2023/0240

3 Eastwell Grove, Wombwell, Barnsley, S73 0NZ

Two storey side and rear extension

DRAWING TITLE:
Proposed Plans & Elevations

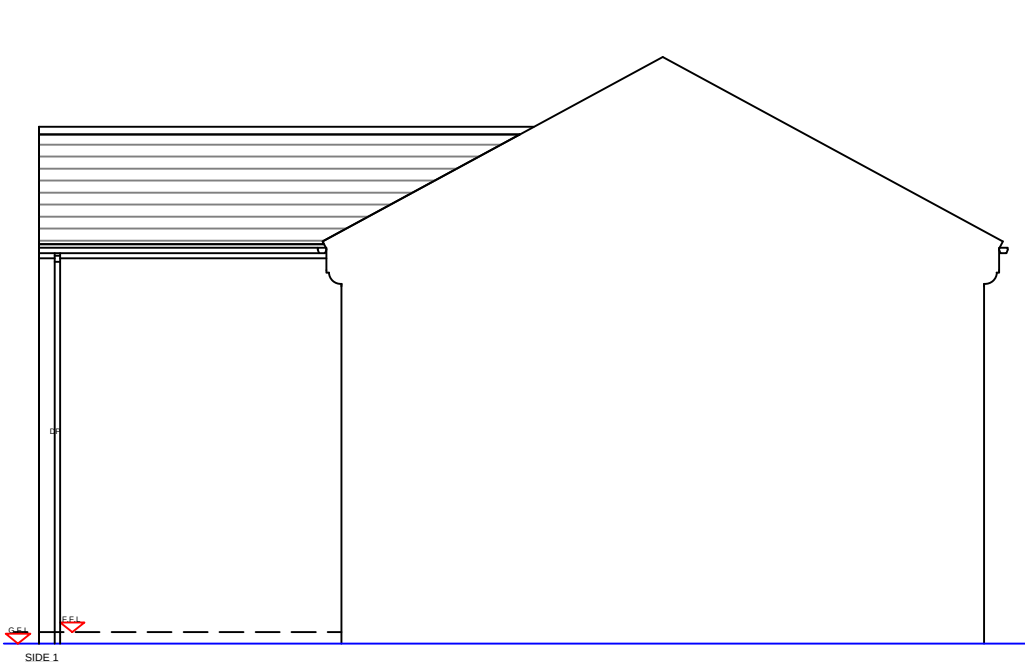
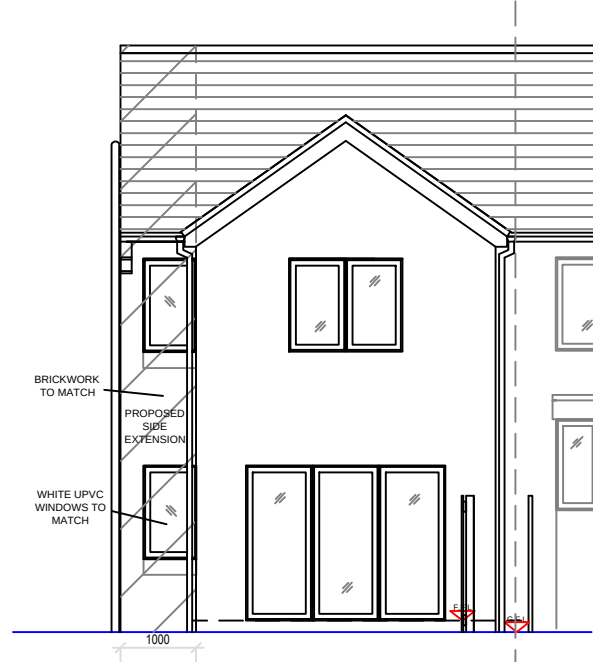
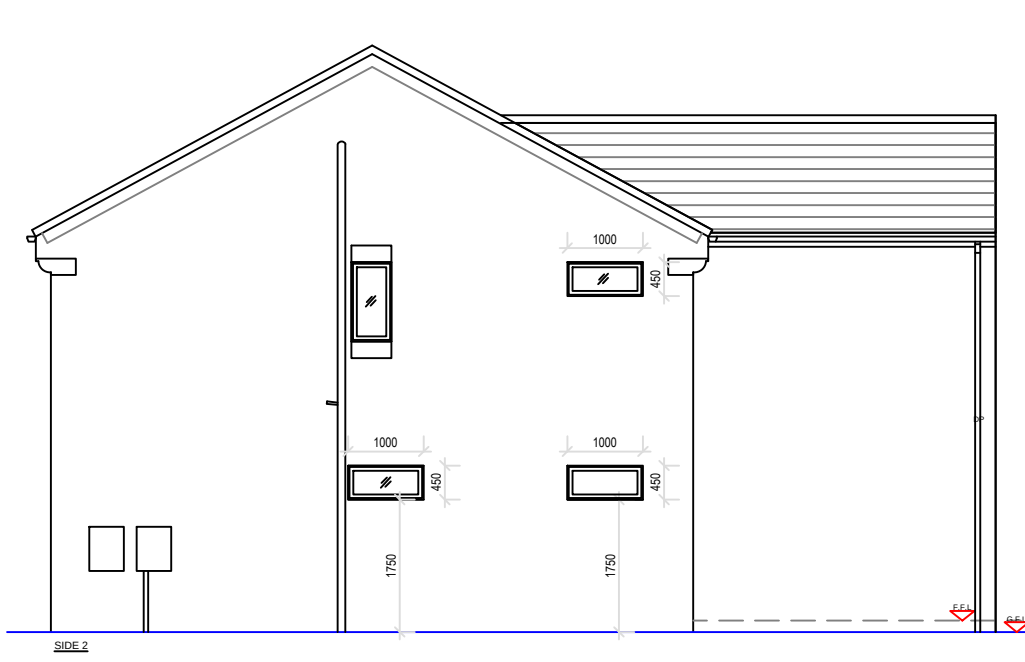
The SPD states *“all two-storey side extensions should therefore have a pitched roof following the form of the existing roof”*. The proposed extension utilises a pitched roof following the form of the existing pitched roof however it is not set down from the main roof line. The lack of a break line within the roof results in an unbalanced dwelling.

The SPD states *“to prevent a terracing effect and to avoid detrimental changes to the character of the street scene, it will be desirable to provide a setback of at least 500mm from the main front wall of the dwelling”*. The two-storey side extension is not setback from the front wall of the dwelling. The lack of a setback means the extension is not subordinate to the host dwelling and impacts upon its character. The extension will not be viewed as an extension of the host dwelling.

The form of the original dwelling is therefore not expressed and there will be an unsightliness of the bonding of the old and new facing materials. The proposed development is therefore considered contrary to policies GD1 and D1 of the Local Plan and the Supplementary Planning Document House Extensions and Other Domestic Alterations.

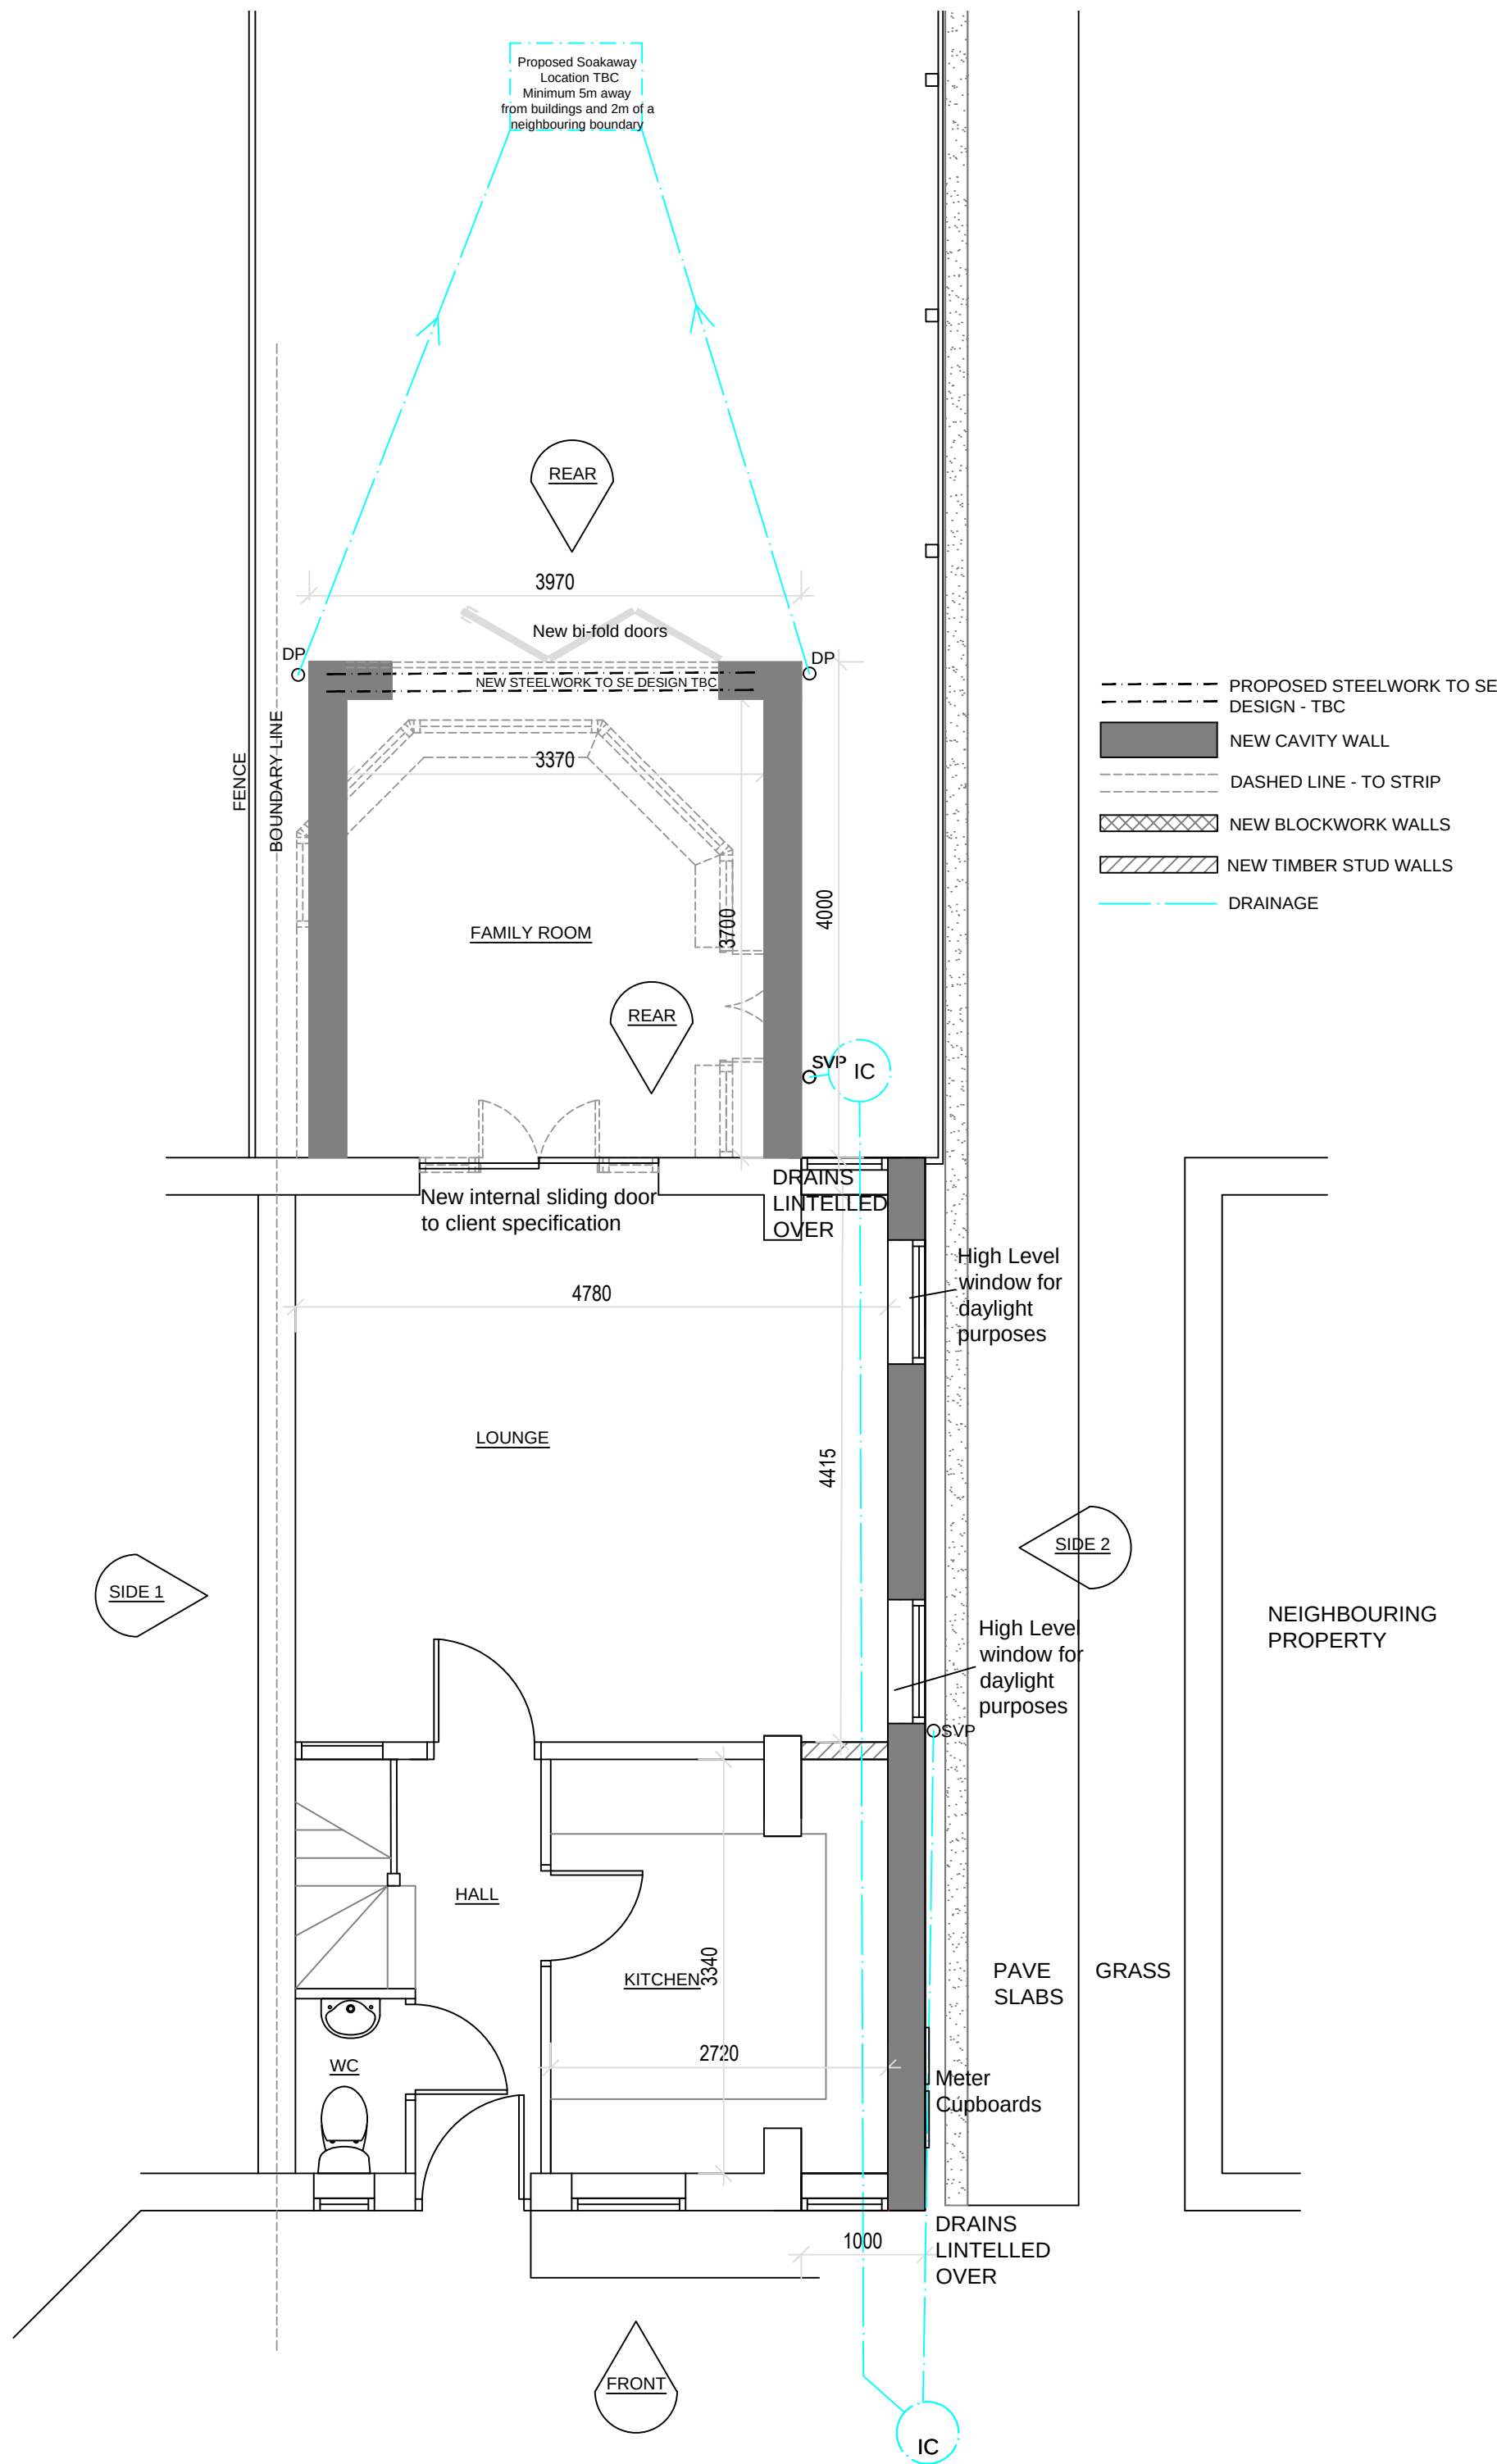
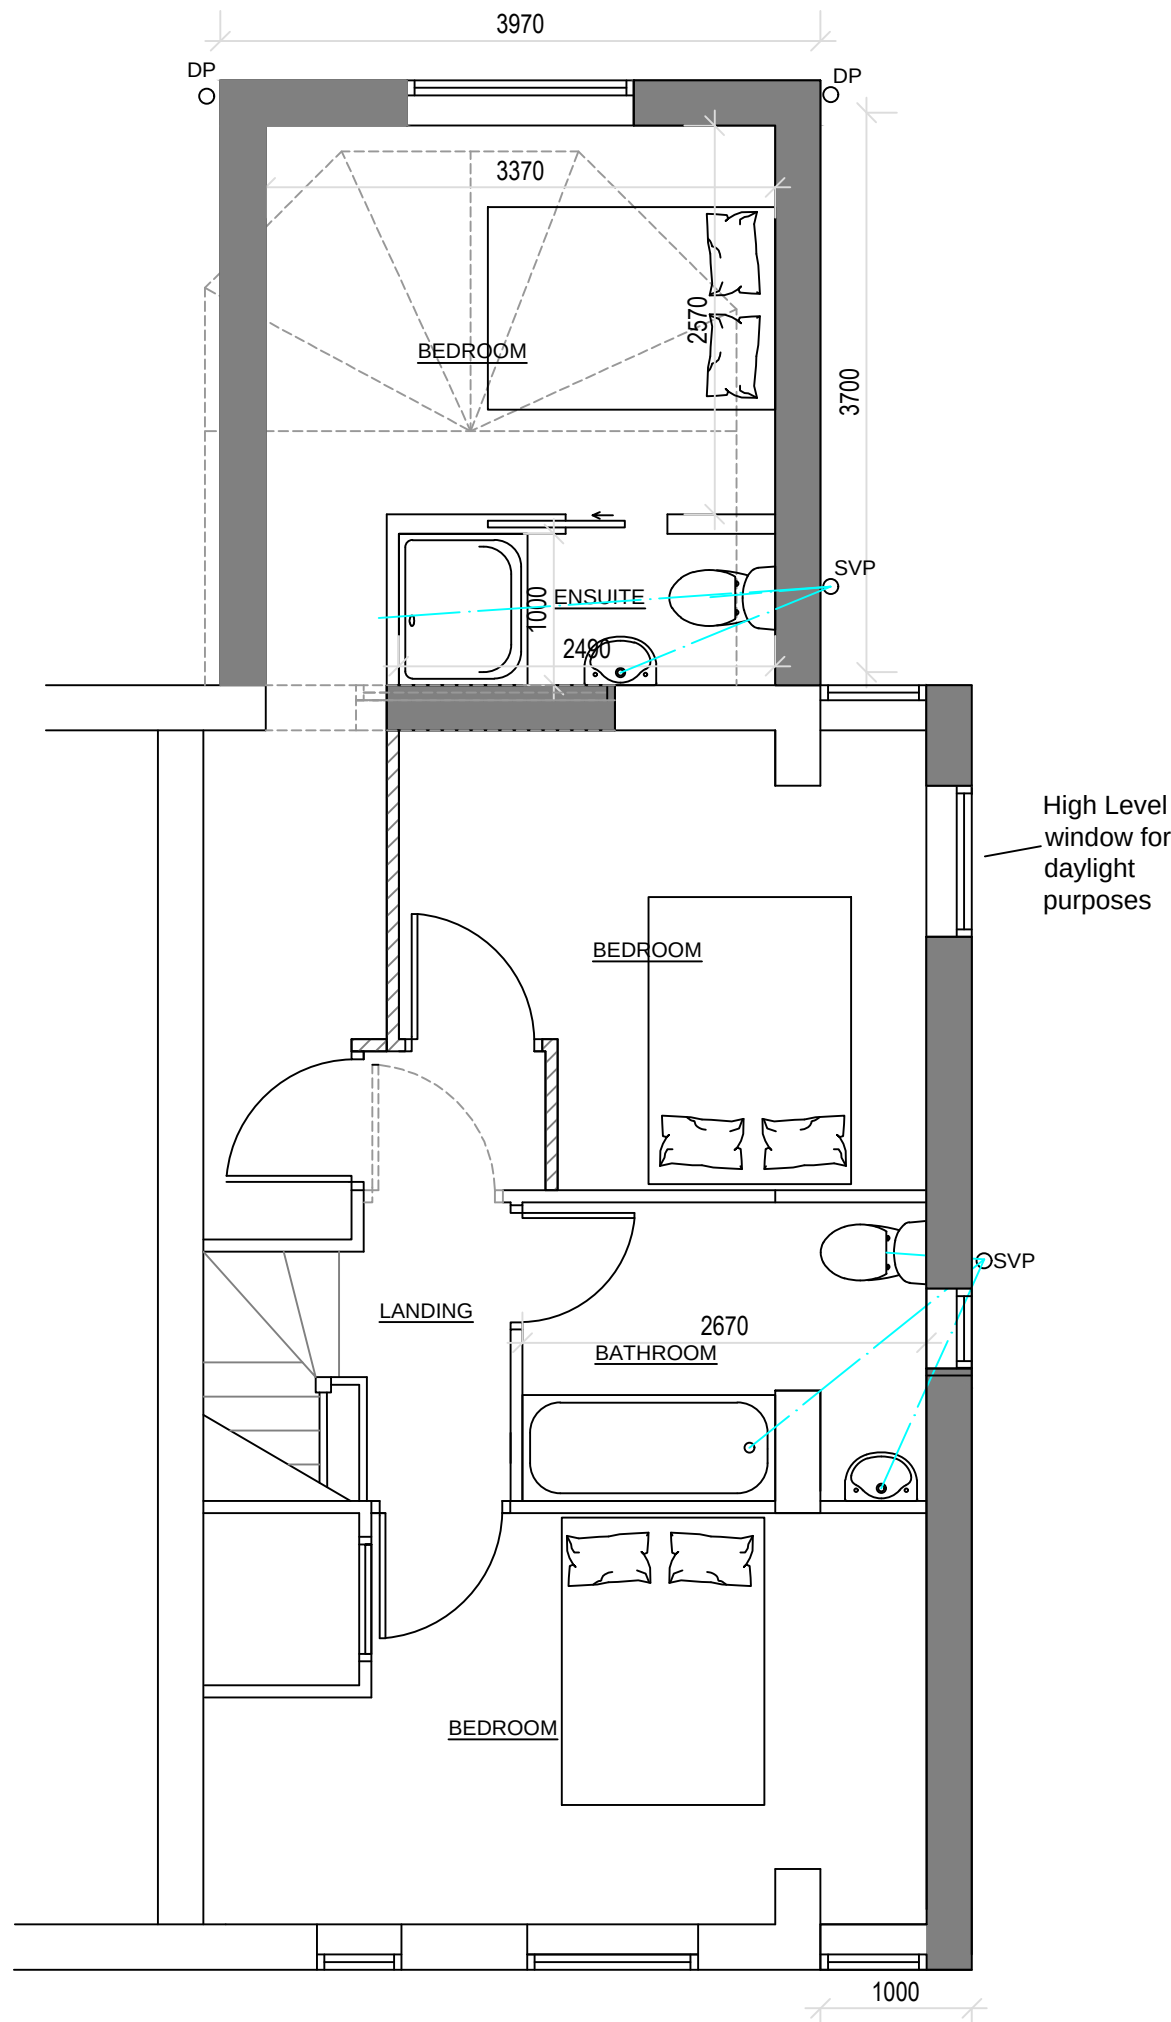
Whilst the SPD states that two storey rear extensions to semi-detached properties should be designed with a rearward's projection of less than 3.5 meters, the South Yorkshire Residential Design Guide provides guidance in relation to daylighting and avoiding overbearing relationships. For the purposes of daylight and to avoid an overbearing relationship with neighbouring properties, particularly adjoining ones, a 45-degree rule is applied to assess the impact a rear extension would have. A 45-degree quadrant is taken from the mid-point of the potentially affected window; if the extension falls within this area, then it is considered that the proposal would have an overbearing impact on the neighbouring dwelling.

The proposed extension is to intersect the 45-degree quadrant by a significant distance well short of the proposed 4-meter projection and it is considered that the proximity of the extension to the party boundary and the substantial expanse of brick work will limit levels of outlook and have an overbearing impact on the adjoining property to the detriment of residential amenity. The SPD states that *“two-storey extensions to terraces and semi-detached properties which abut a party boundary and adversely affect main windows will not normally be allowed”* and *“two-storey rear extensions to semi-detached houses should, therefore, generally be designed with a rear projection of less than 3.5 metres”*. Even with a reduction in the projection to 3.5 meters this would not negate the issue of overbearance and the loss of outlook to the adjoining dwelling.

Proposed Block Plan

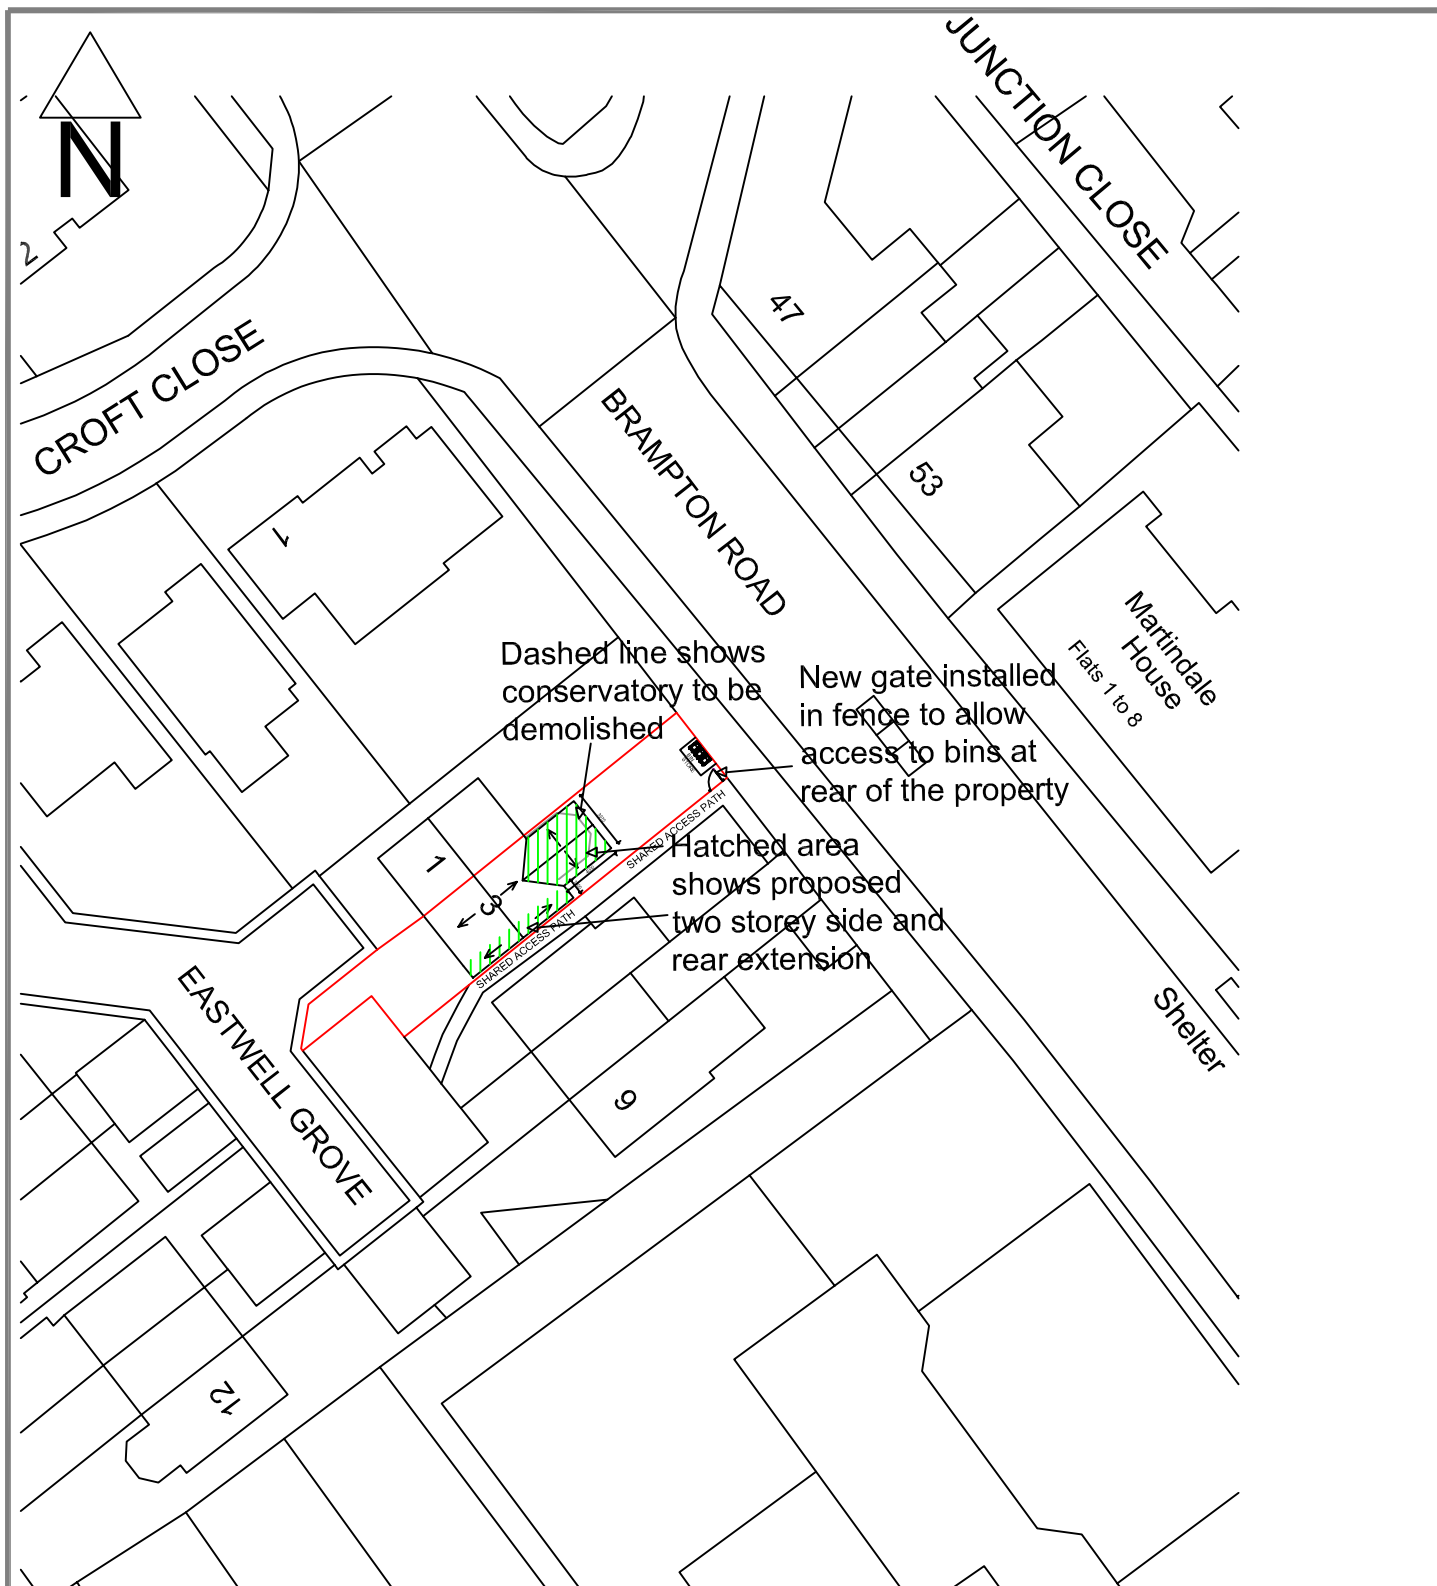
There will be an impact upon highway safety. The dwelling at present doesn't feature a parking space as from the location plan the parking spaces present on Eastwell Grove do not fall within the red line boundary of the application site. None the less although there is the number of spaces present for one to be assigned to the dwelling there is clearly not the provision for two spaces. Two spaces are required as the number of bedrooms in the dwelling is to be increased to three therefore increasing the parking provision to two spaces of which are not presently provided.
